Rezoning Transportation Analysis

Petition Number: 2023-012

From: Jake Carpenter, PE
Jacob.carpenter@charlottenc.gov
980-221-5675

Date	Description
5-24-23	First Review (PDM)
6-21-23	Second Review (DR)

REZONING
SITE PLAN

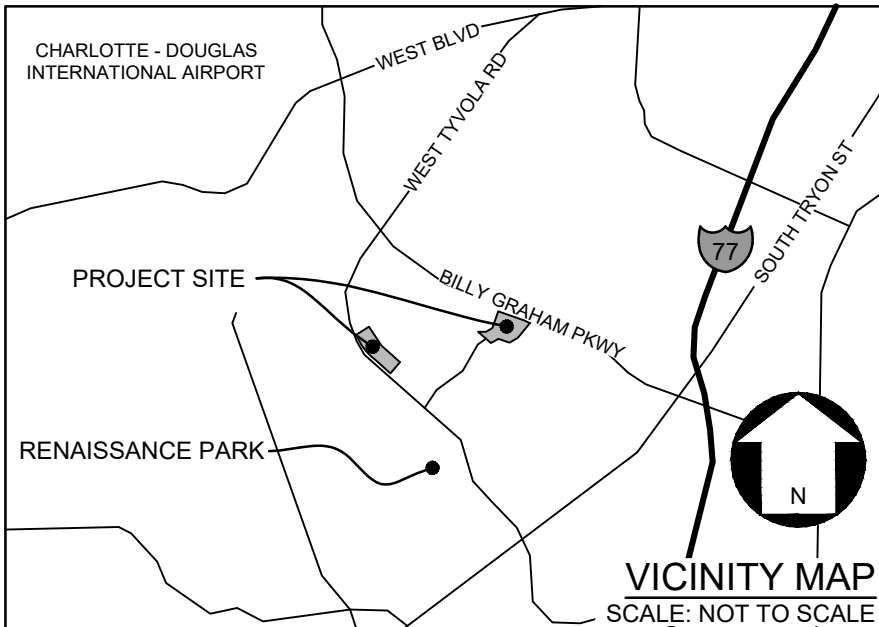
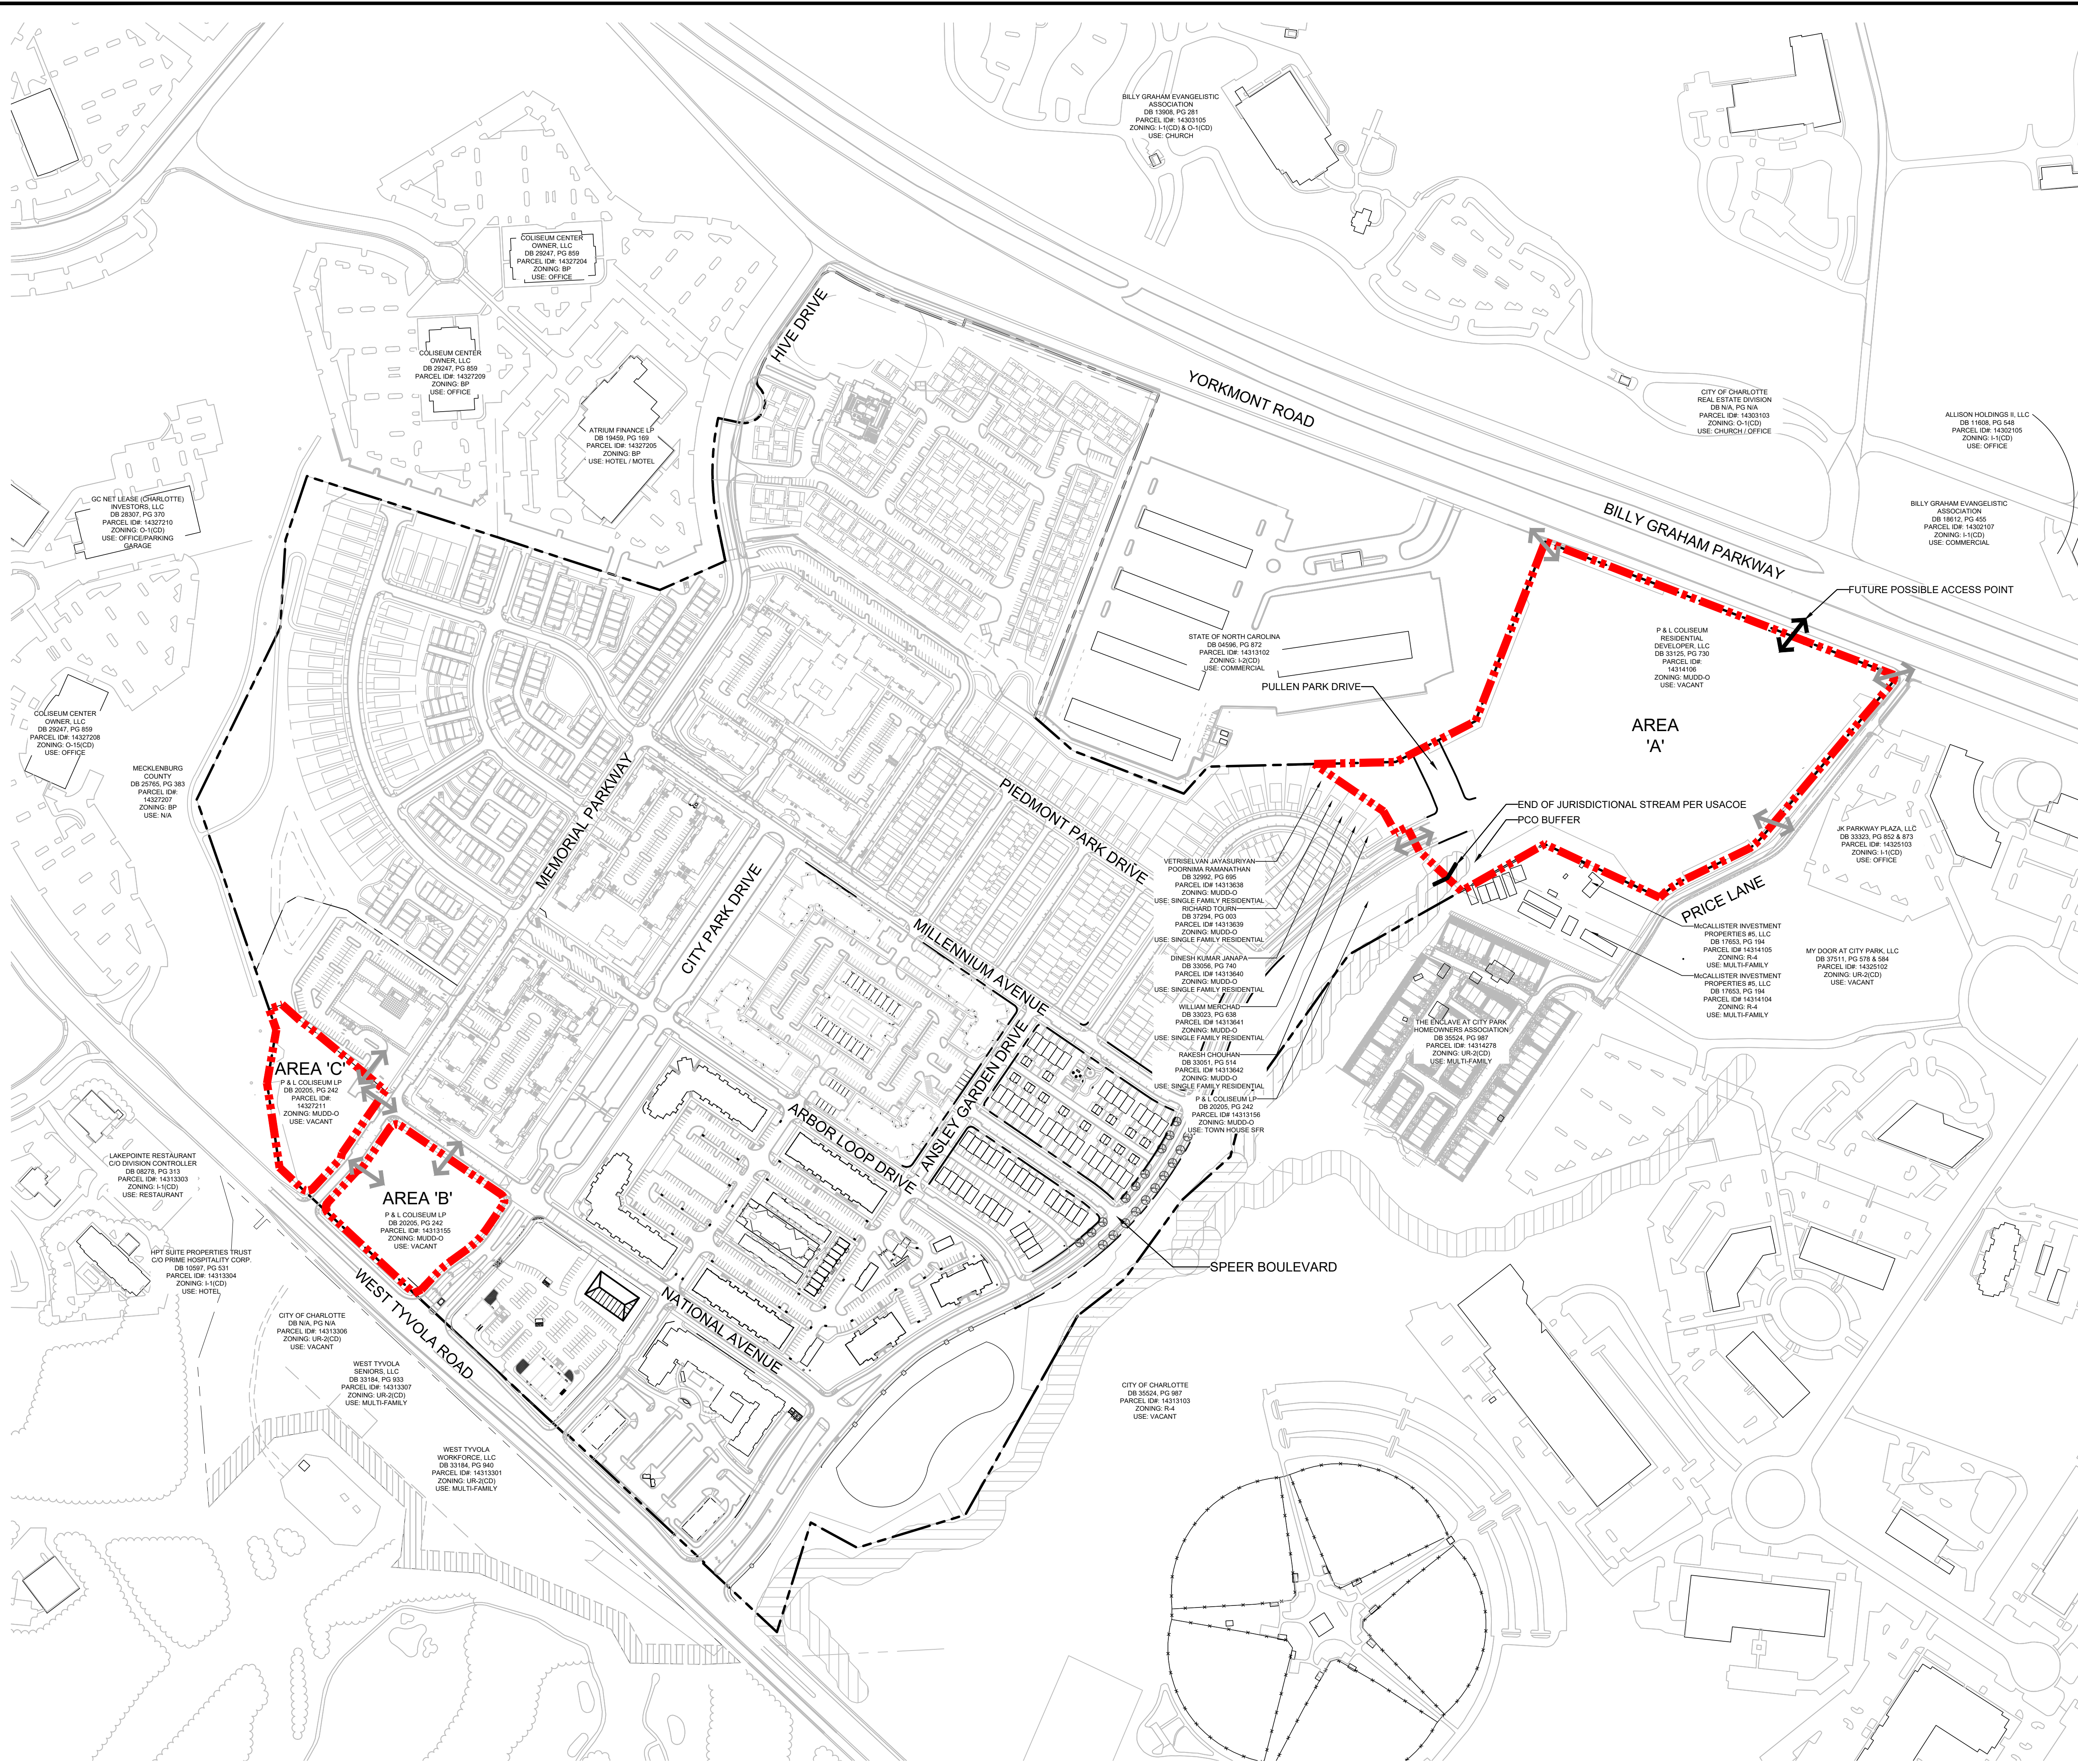
Label and dimension the curb and gutter from the centerline for each road on the site plan.

Outstanding Comment from 6.21.23: Label and dimension the curb and gutter from the centerline for each road on the site plan.

3. Revise site plan and conditional note(s) to commit to dedicate a minimum of 35 feet of right-of-way from the road centerline on Yorkmont Road and Speer Boulevard. The site plan shall label and dimension the right-of-way from the road centerline.

Clarifying comment 6.21.2023: Add conditional note to dedicate a minimum 35 feet of ROW from the roadway centerline of Yorkmont Road and Speer Boulevard. Additionally label and dimension.

4. Revise site plan and conditional note(s) to commit to provide an 8-foot planting strip, and 8-foot sidewalk along Yorkmont Road and Speer Boulevard per the Charlotte Streets Map.

Clarifying comment 6.21.2023: Add conditional note to provide 8-foot planting strip and 8-foot sidewalk along Yorkmont Road and Speer Boulevard. Additionally, revise to show 8-foot sidewalk.

5. Revise site plan and conditional note(s) to commit to construct bicycle facilities by locating the curb and gutter 18.5' on Speer Boulevard and 24' on Yorkmont Road from the center line/installing a bike lane to meet the Council-adopted Charlotte BIKES Policy.

Clarifying comment 6.21.2023: Add conditional note to construct bicycle facilities on Speer Boulevard and Yorkmont Road.
